May 15, 2013

**Re: Church's Chicken Store 695, 5407 Central NW, Traffic Circulation  
Layout, Architect's Stamp dated 5-08-13 (K11-D081)**

Cynthia K. Beck  
Traffic Engineer, Planning Dept.  
Development Review Services

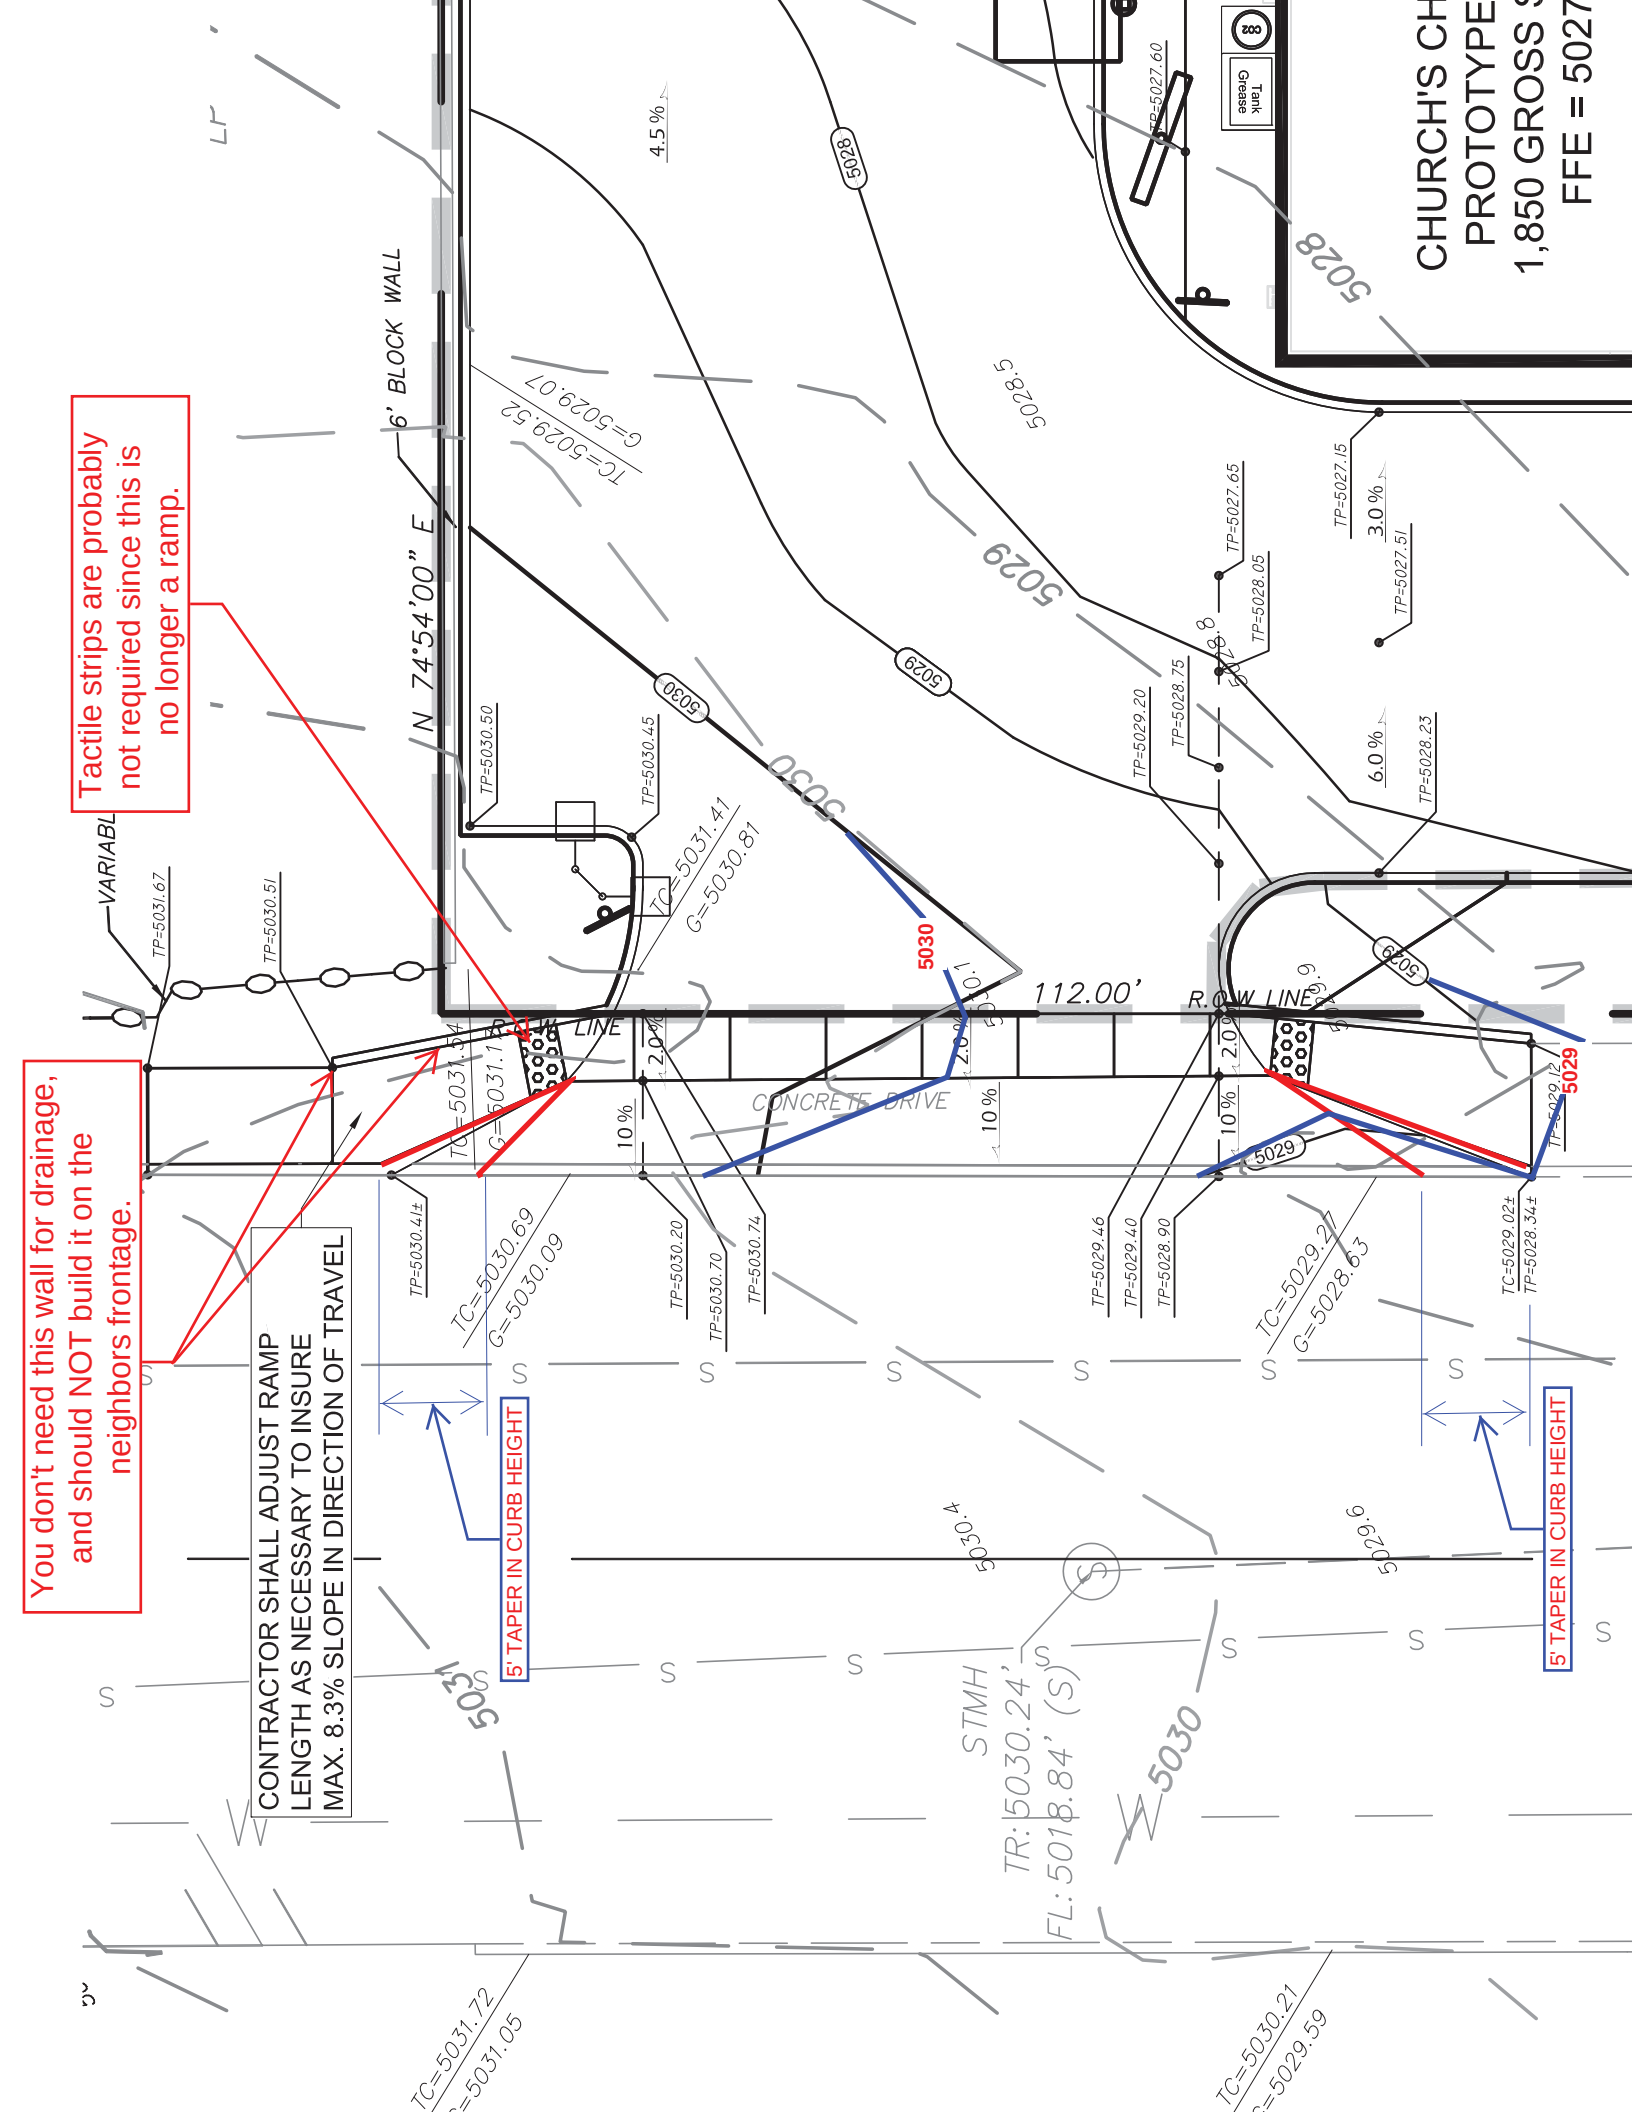
5. Define width of the existing sidewalk along both COA ROW frontages .
6. List the width of the existing drive pads.
7. List the width of the proposed turnouts.

8. Show a detail of the wheelchair ramps located at the proposed driveway, or refer to the appropriate city standard.
9. Single entrance driveways allowing right-in /right-out-only movement have a minimum driveway width of 30 feet and minimum turning curb radii of 25 feet if located on an arterial roadway. Central Ave is classified a principle arterial. See the *Development Process Manual*, Chapter 23, Section 6, Part B.8 for regulations.

10. Per Chapter 23, Section 6, Part B.5 of the City of Albuquerque *Development Process Manual*, any drive on a principle arterial (Central Ave) intersecting a collector (Yucca Drive) must be located a minimum of 200 feet from the intersection. Please provide the setback distance of the proposed drive pad from this intersection.

12. The drive through facility requires a minimum 12 foot lane width with 25 foot radii on all inside turns. A 15 foot radius can be used with 14 foot wide drive thru lanes (see DPM Ch 23, Section 7, Part E).

15. A 6 foot wide ADA accessible pedestrian pathway is required between the public sidewalk on Central Ave. and the entrance to the building.
16. The proposed pylon sign to be reused may not interfere with the sight distance of the intersection nor the clear sight triangle adjacent to drive pads. Please provide a sight distance exhibit (see the *Development Process Manual*, Chapter 23, Part B, Section 5.a).
